Rezoning Transportation Analysis
Petition Number: Insert Zoning Petition #2021-056
General Location Identifier: 04105416

Revision Log:

Date	Description
05-27-2021	First Review (EL)
08-24-2021	Second Review (BB)
09-24-2021	Third Review (BB)
10-18-2021	Fourth Review (WB)
01-27-2022	Fifth Review (PDM)
03-02-2022	Sixth Review (PDM)

The site is located on a City-maintained local road (B Avenue), east of Beatties Ford Road, a City-maintained major thoroughfare. There is unmaintained right-of-way adjacent to the site where a new public roadway (C Avenue) will be constructed. The petitioner is installing public streets along the existing unmaintained right-of-way. Site plan revisions are to callout the existing alley as a privately maintained alley. Further details are listed below.

Drawing No. **RZ-2.0**

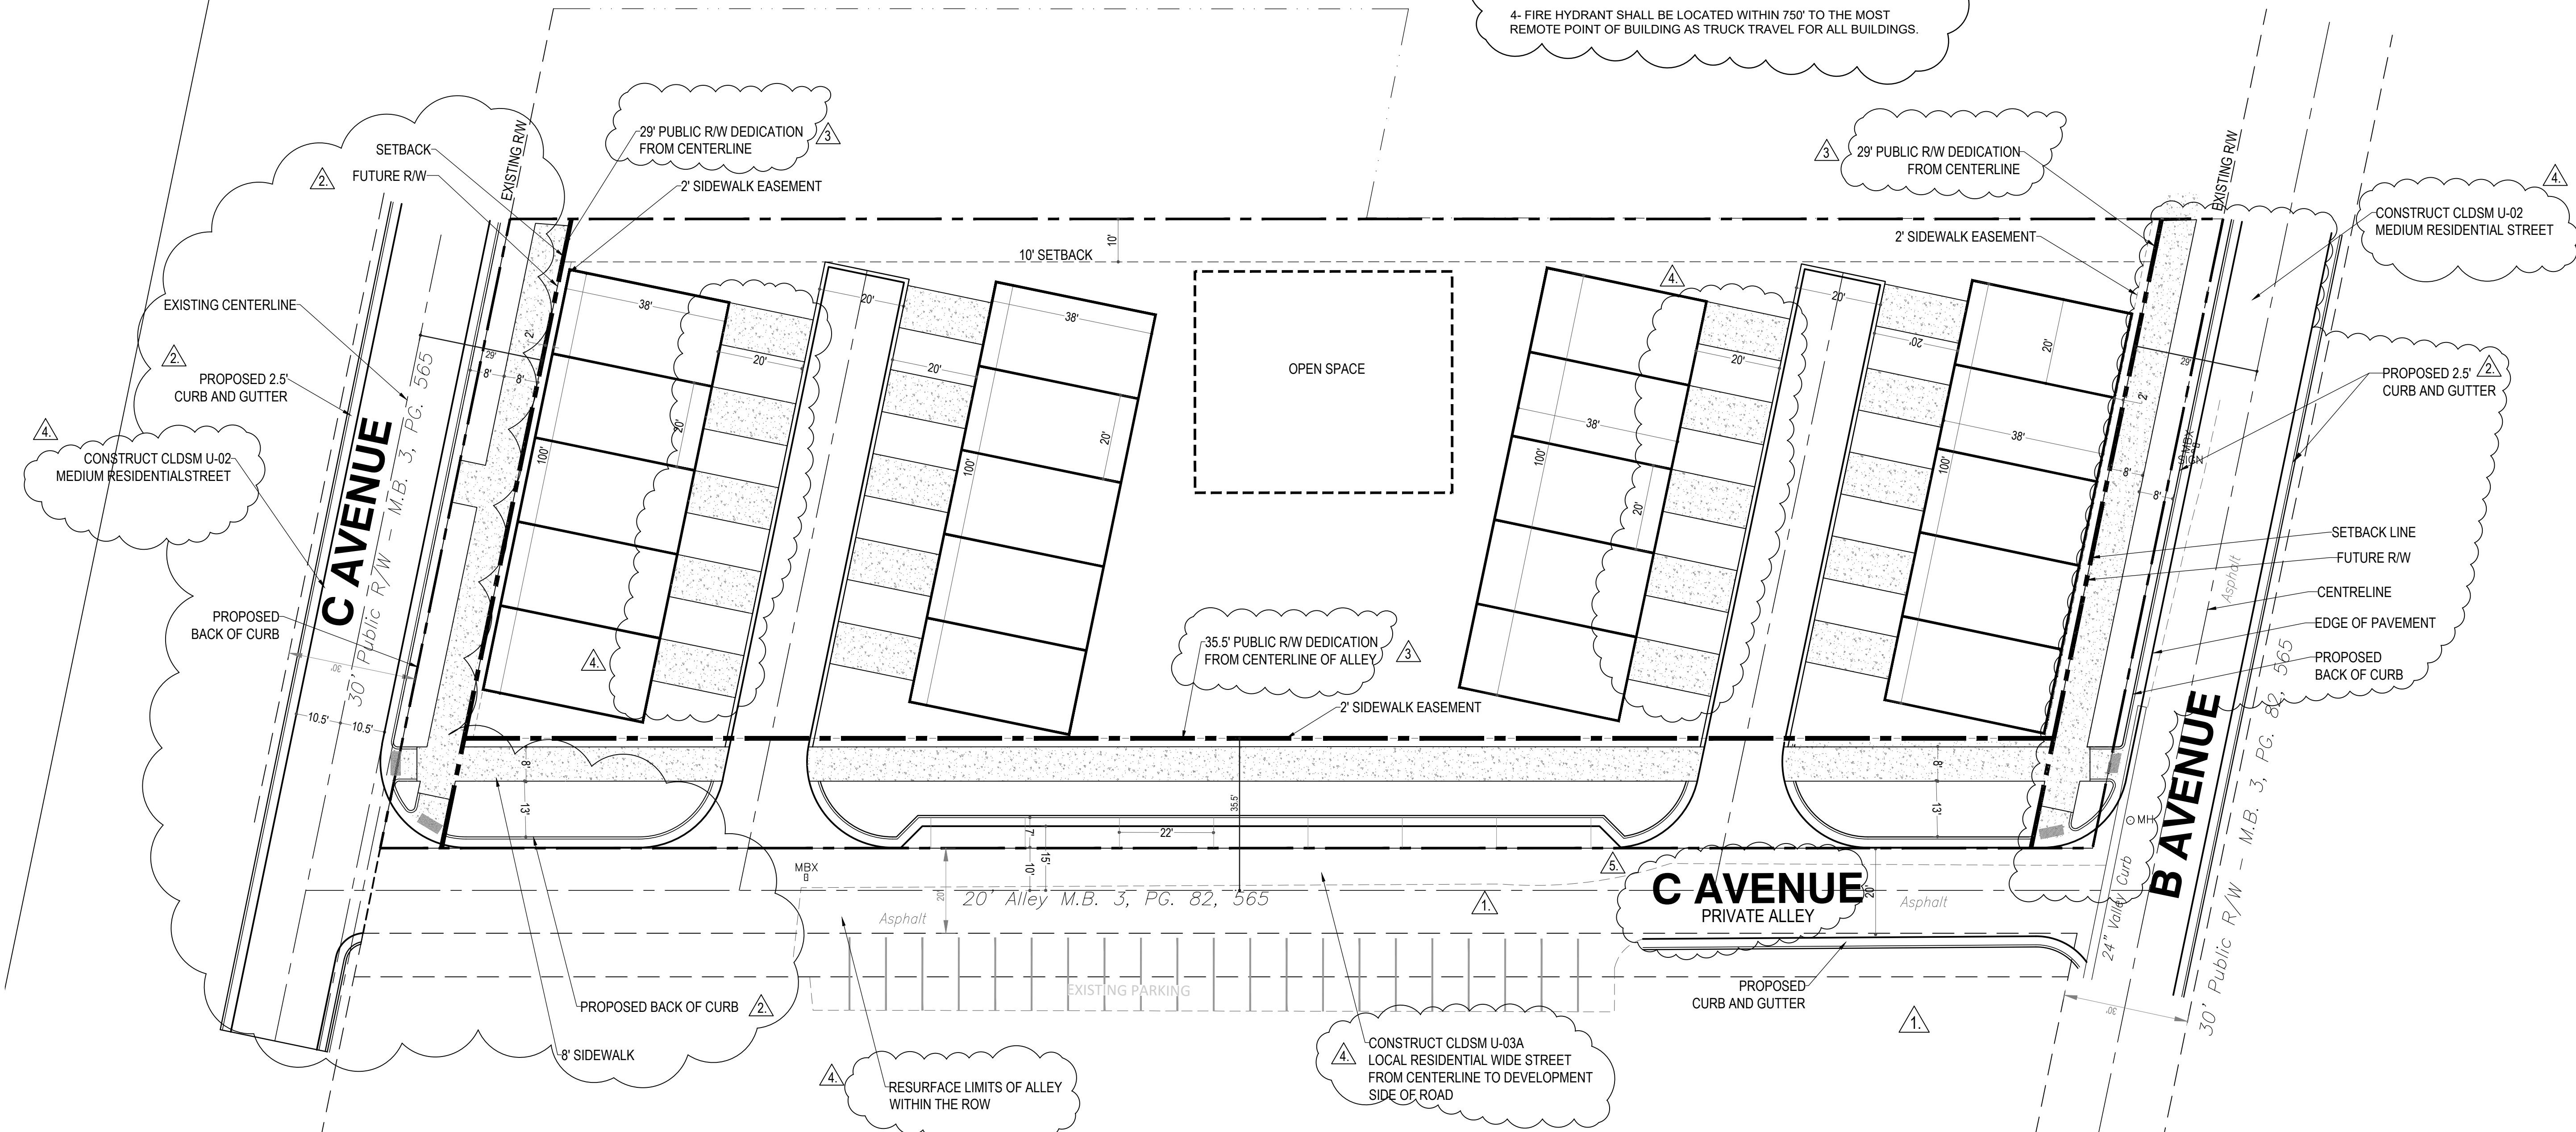
Revise site plan and conditional note(s) to commit to dedicate 28 feet of public right-of-way from the North Avenue and B Avenue road centerlines. The site plan shall label and dimension the right of way from the road centerline, per CLDSM standard detail number U-02—*Local Residential Medium Street Typical Section*.

3. Outstanding Comment: Revise site plan and conditional note(s) to commit to dedicate 35.5 feet of public right of way from the alleyway centerline, if public right of way is already platted. The site plan shall label and dimension the right of way from the road centerline, per CLDSM standard detail number U-03—*Local Residential Wide Street Typical Section*. If this is confirmed to only be a 20-foot wide alleyway, coordinate with CDOT to determine the appropriate requirements.

4. Outstanding Comment: Revise site plan and conditional note(s) to commit to construct an 8-foot planting strip and 8-foot sidewalk on all public street frontages per Chapter 19 / Chapter 20 of the City Code and the Charlotte WALKS Council-adopted policy. 8-foot sidewalk is needed since more than 12 dwelling units per acre is proposed.

5. Outstanding Comment: Revise site plan and conditional note(s), including Site Plan Conditional Note 3.a, Access, Transportation, and Improvements to extend the Residential Wide typical section on the alleyway / paper right of way to (east-west) C Avenue (now labeled as C Avenue).

6. **Outstanding Comment:** Revise site plan and conditional note(s) to commit to construct two PROWAG ramps at the alleyway / paper right of way intersections with North Avenue (now labeled C Avenue) and B Avenue (**Comment clarification on 10/18/21** – two ramps per corner).

7. **Outstanding Comment:** A site plan note(s) specifying dedication and fee simple conveyance of all rights-of-way to the City before the site's first building certificate of occupancy is issued is needed. CDOT requests rights-of-way set at 2' behind back of sidewalk where feasible.

9. **New Comment (revised on 01/27/2021 based on updated site plan):** Revise site plan and conditional notes to specify Avenue B and Avenue C (formerly labeled as North Ave) as residential medium streets per CLDSM U-02. The site plan shall call out each road as CLDSM U-02. A conditional note shall be added to the plans stating Avenue B and Avenue C (formerly labeled as North Ave) will be constructed to the standard outlined in CLDSM U-02.

10. ~~New Comment (revised on 01/27/2021 based on updated site plan):~~ Revise site plan and conditional notes to specify Avenue C alley as residential wide streets per CLDSM U-03A. The site plan shall call out the road as CLDSM U-03A. A conditional note shall be added to the plans stating Avenue C Alley will be constructed to the standard outlined in CLDSM U-03A from the centerline of the road to the development side of the road as outlined in previous memo comment 1.C.
11. ~~New Comment (revised on 01/27/2021 based on updated site plan):~~ Revise site plan and conditional notes to commit to resurfacing the entire limits of C Avenue Alley within the right of way in accordance with the pavement schedule outlined in CLDSM U-03A. This includes the area from the centerline of the road to the right of way line to the west side of the roadway.

12. ~~Outstanding Comment (revised on 01/27/2021 based on updated site plan):~~ Revise site plan to relocate the multi-use path along C Avenue alley to reduce the planting strip to 8ft along the roadway (locate multi-use path 10.5 feet from the edge of travel lane). Based on the current site plan for the townhomes, the setback from the right of way required by zoning is not met. Confirm setback requirements with zoning. Right of way dedication can be reduced to 2ft behind the relocated multi-use path (30.5 ft from centerline).
13. **New Comment 03/02/2022:** Revise site plan to call out the C Avenue alley as privately maintained.
